Date: 18-Jun-2025
Our Ref: 2025/90314

**Application for Approval of Details Reserved by Condition
Town and Country Planning Act 1990
Planning (Listed Buildings and Conservation Areas) Act 1990**

**Discharge of details reserved by conditions 3,4,5,6,7,8,9,10,11,12,13,
14,16,17,18,19,25,26 & 27 on previous permission 2024/90839 for erection of 7
Dwellings and associated infrastructure following partial demolition of existing
Public House (within a Conservation Area)
Rose And Crown Inn, 132, Knowl Road, Golcar, Huddersfield, HD7 4AN
Application Number: 2025/90314**

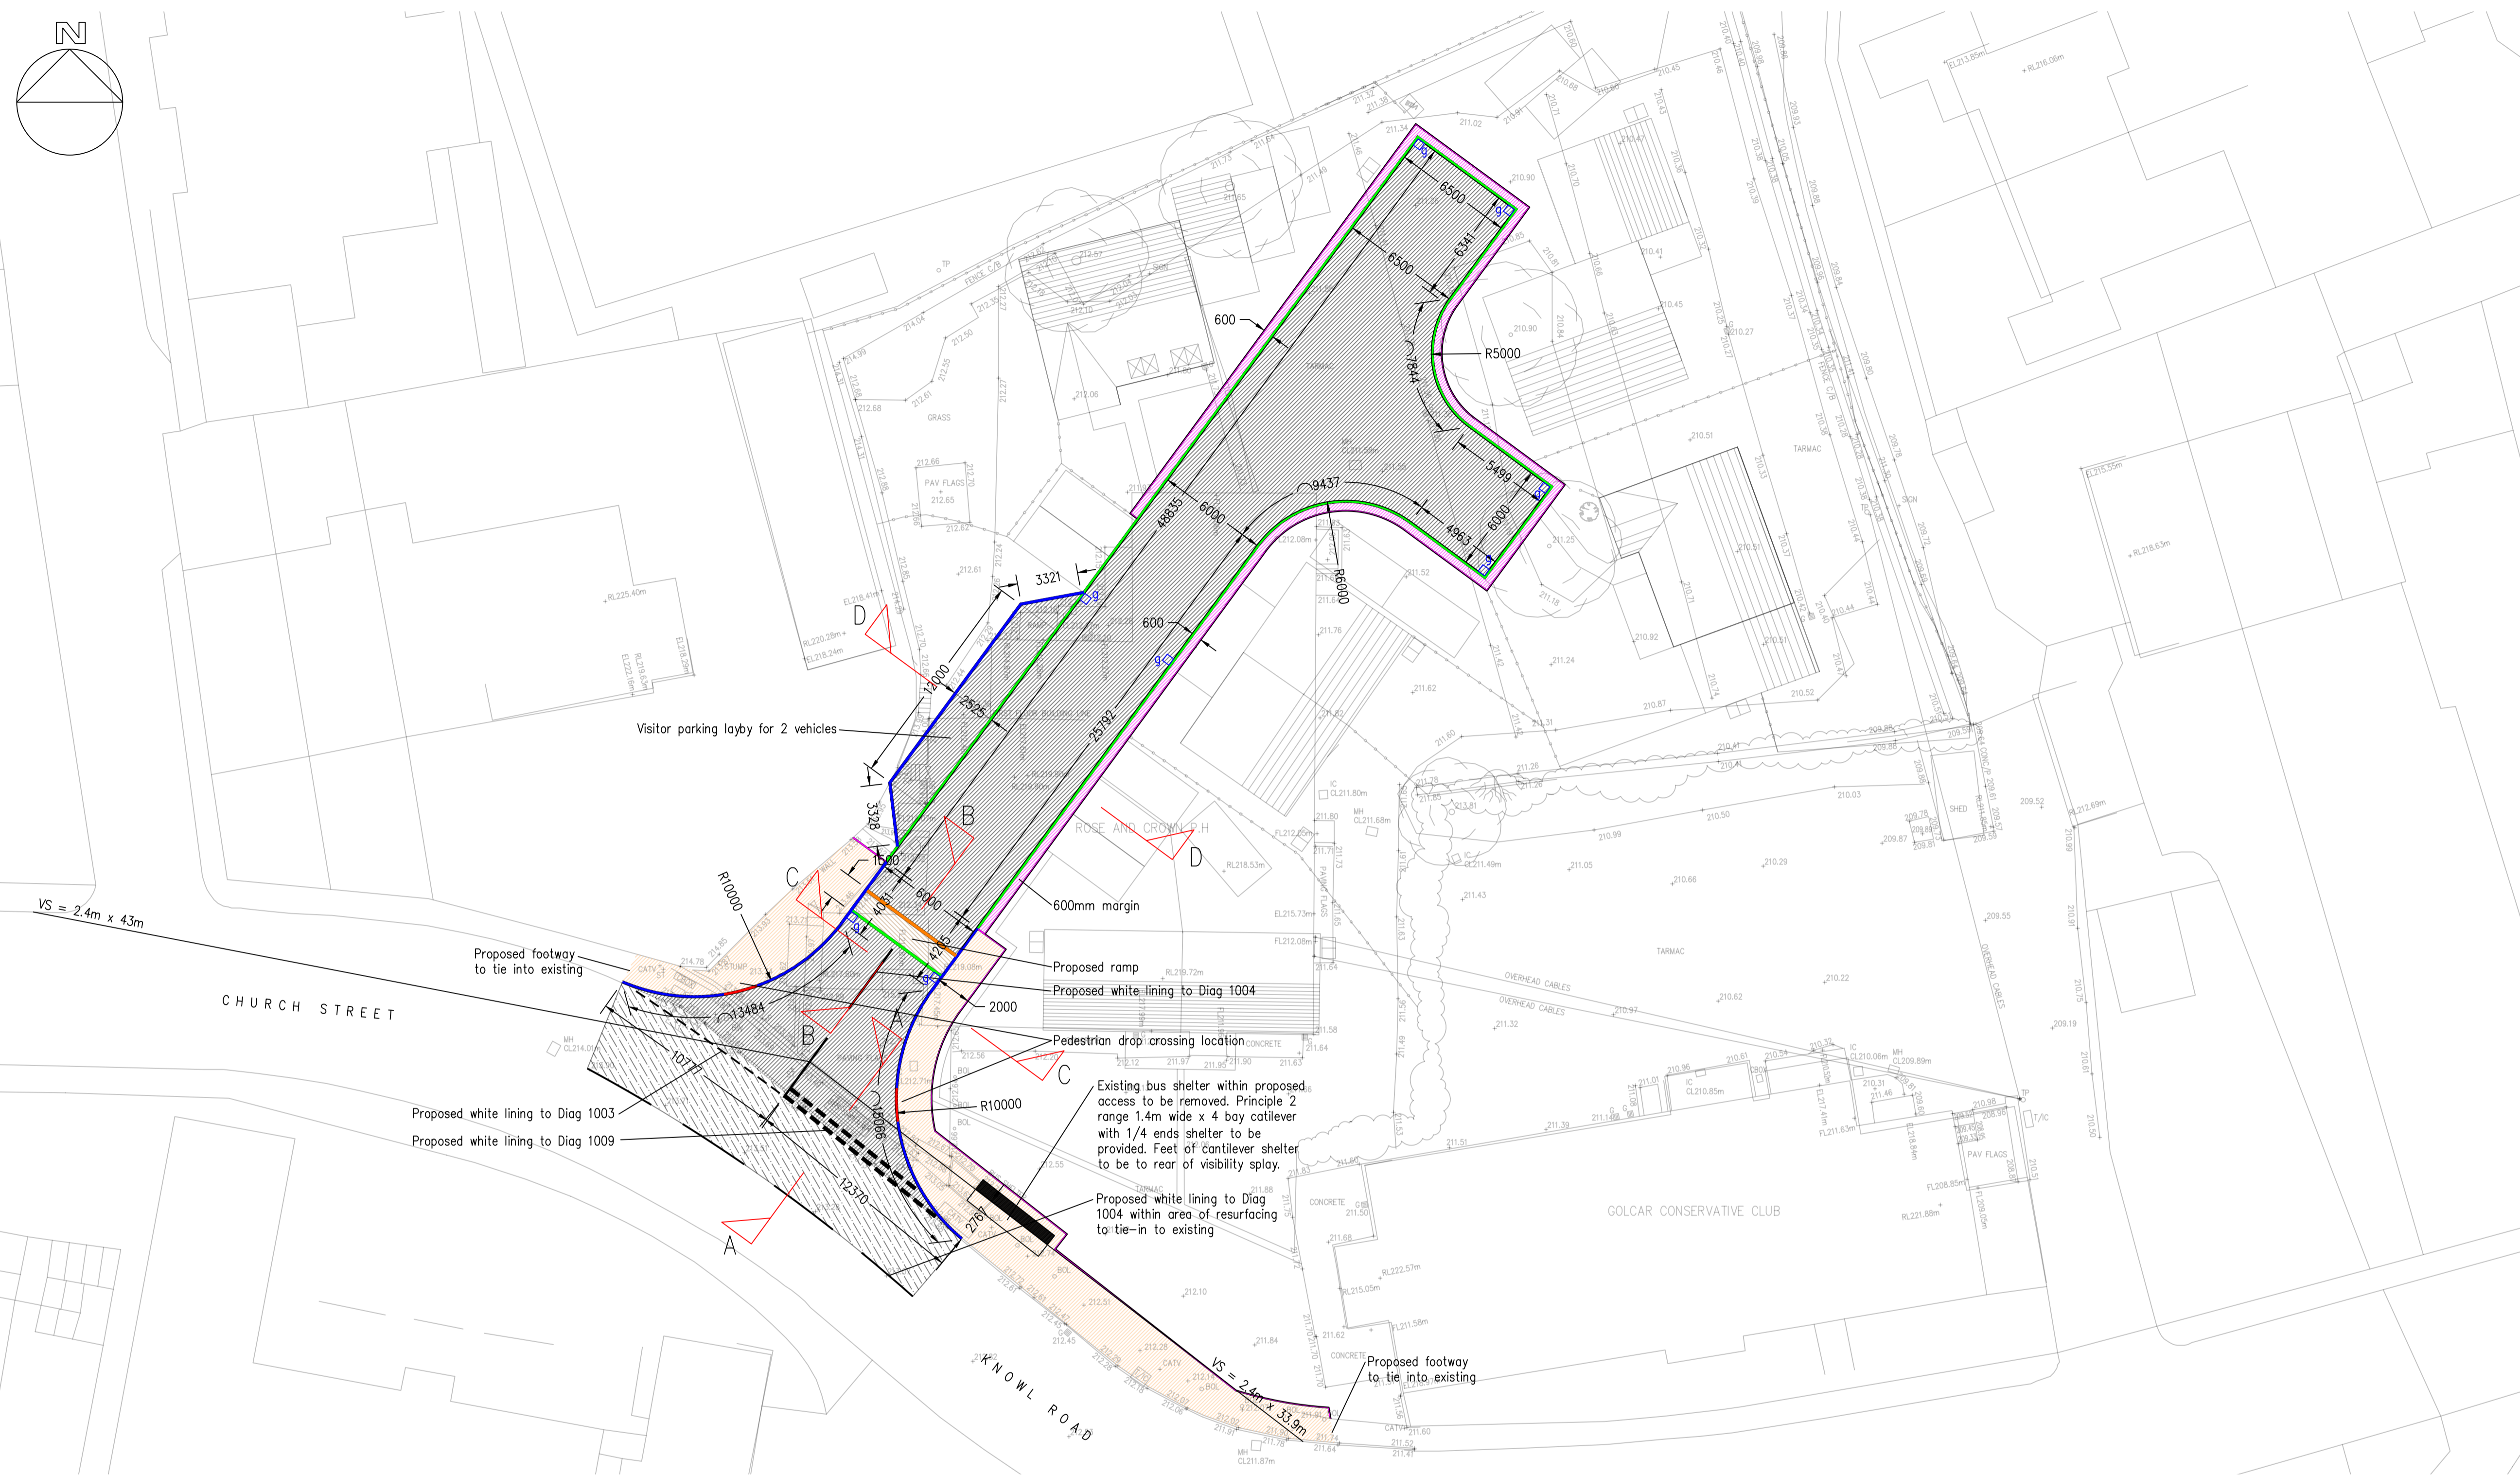
- The scheme does not show the existing or proposed highway boundary.
- No road safety audit documentation has been provided
- The details submitted are unclear as to whether pedestrians would have to enter private land to be able to cross the Bellmouth safely.
- The 'Kerbs and Surfacing' drawing does not show tactile paving to the proposed pedestrian crossing point, even though this is required by the CDM regulations.
- The revised plans show the proposed bus shelter outside the visibility splay. A road safety audit in regards to the location of the bus stop and shelter is required to enable an informed decision and fully assess this aspect of the scheme.

On this basis the Highways Team confirm this condition cannot be discharged. It is concluded that, given the response of the Highways Team, conditions 14 and 17 are required to remain in place.
